SHOALHAVEN CITY COUNCIL
ENVIRONMENTAL ASSESSMENT SUBMISSION TO THE NSW DEPARTMENT
OF PLANNING PART 3A, ENVIRONMENTAL PLANNING & ASSESSMENT ACT, 1979

MAJOR PROJECT APPLICATION MP 06_0205

Vincentia District Centre
Modification No 5

PROPOSAL: Proposed MP06_0205 VDC Stage 1 - Modification No 5 being a modification to the VDC Stage 1 approvals issued in Modifications 2, 3, and 4.
Delivery of the VDC in two stages with an amended floor layout design and Statement of Commitments and proposals for a fuel and fast food outlet in Stage 1.

**Existing Thursday afternoon peak hour traffic flows plus Stage 2 development traffic**

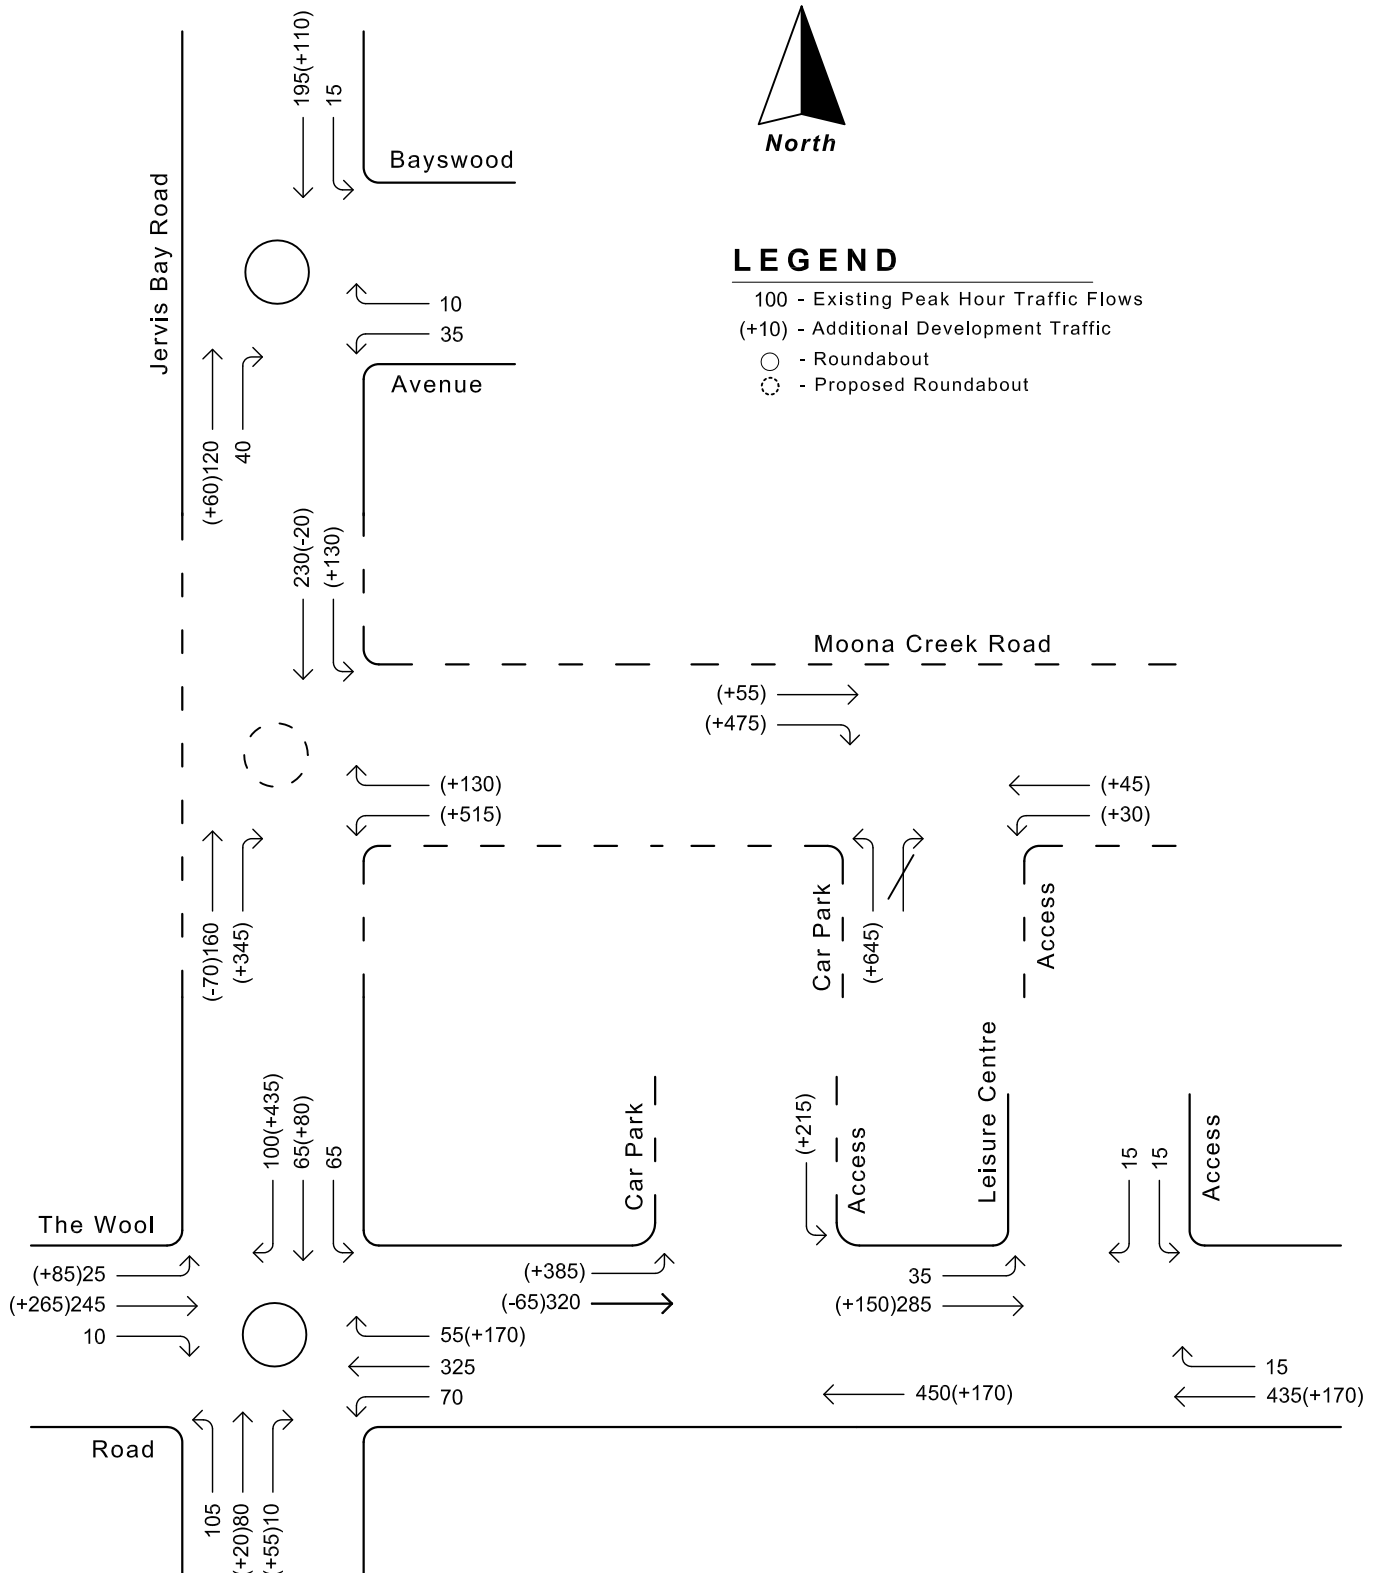
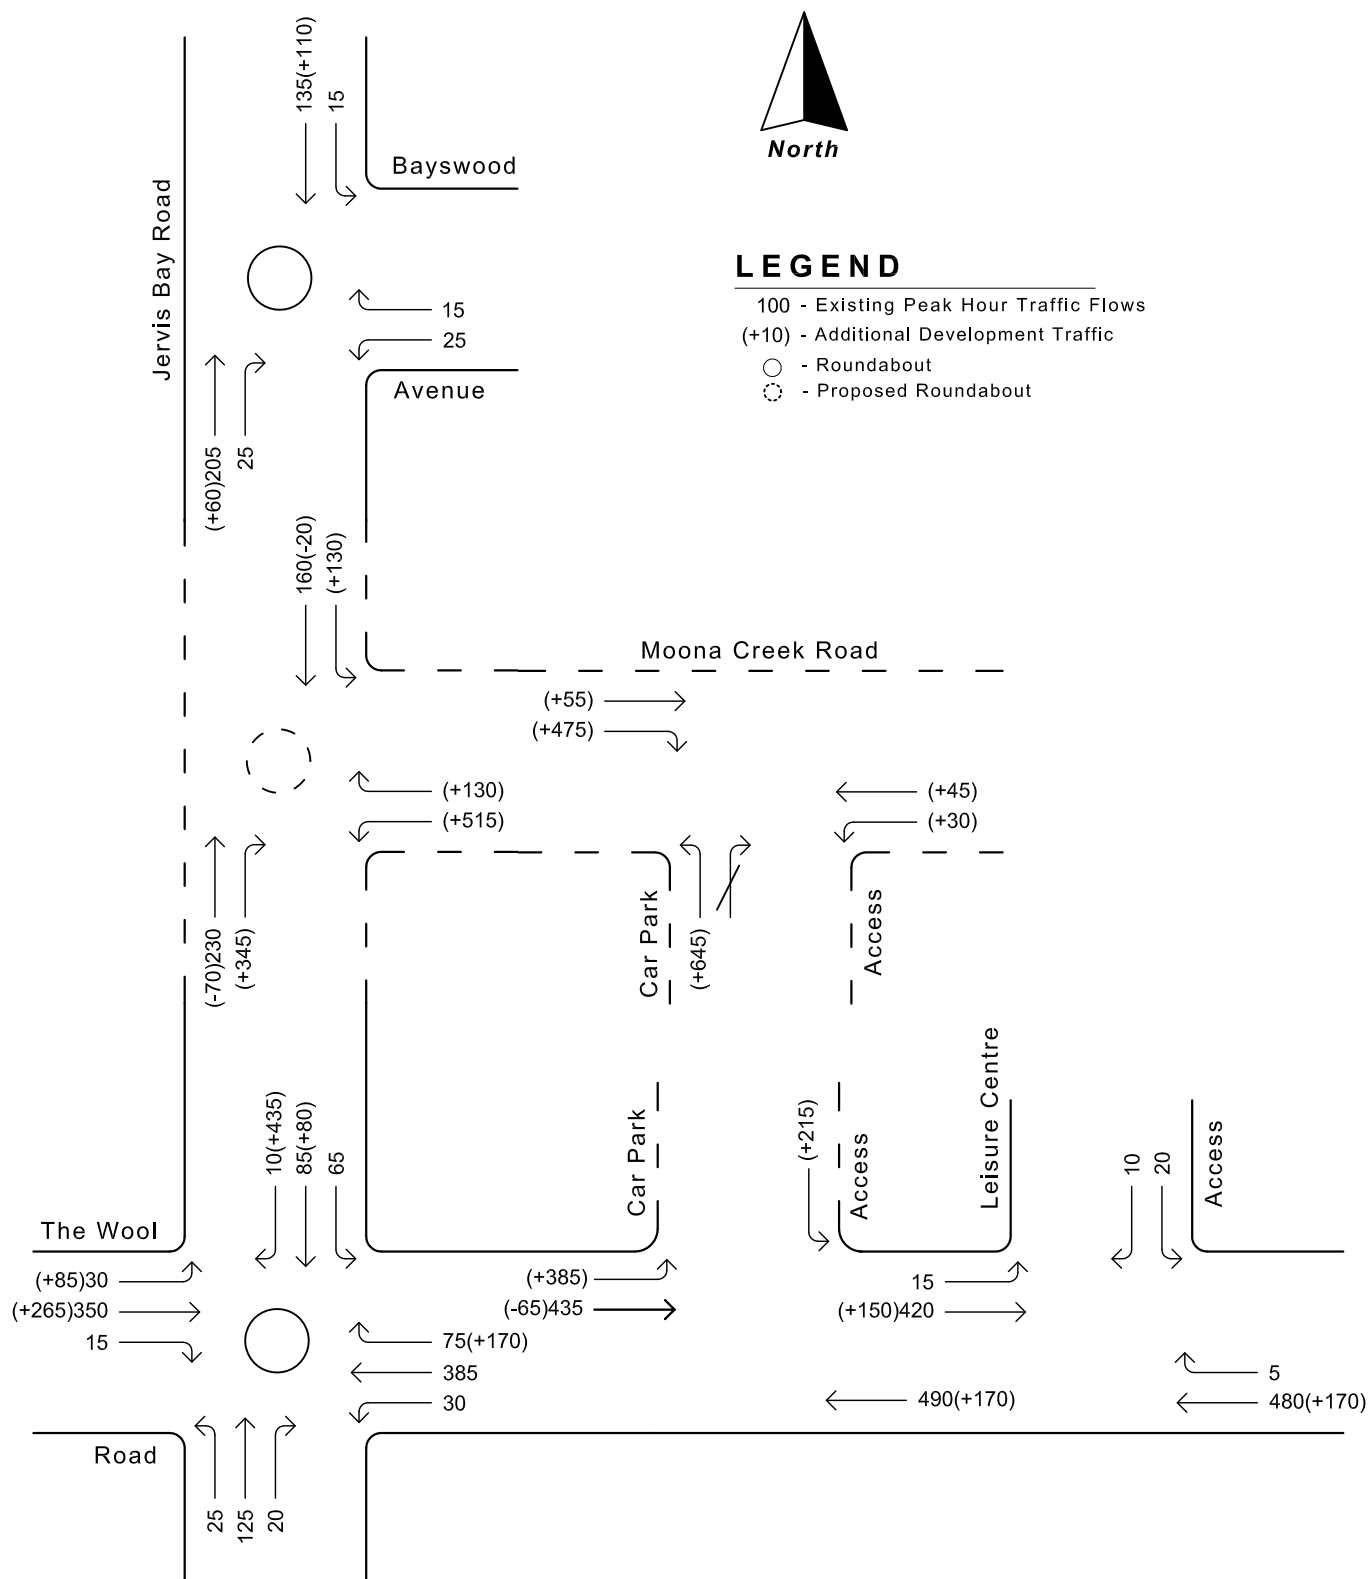
3.6.3.3 The existing roundabout at the NCR/TWR intersection provides for single lane movement. The CBHK Stage 2 report requires this roundabout be upgraded to two circulation lanes on all legs except the southern leg (Jervis bay Road).

It is considered that the requirements for this roundabout in the CBHK Report should be included as a Stage 2 SoC. This is consistent with SoC 51 of the Concept approval in 2007.
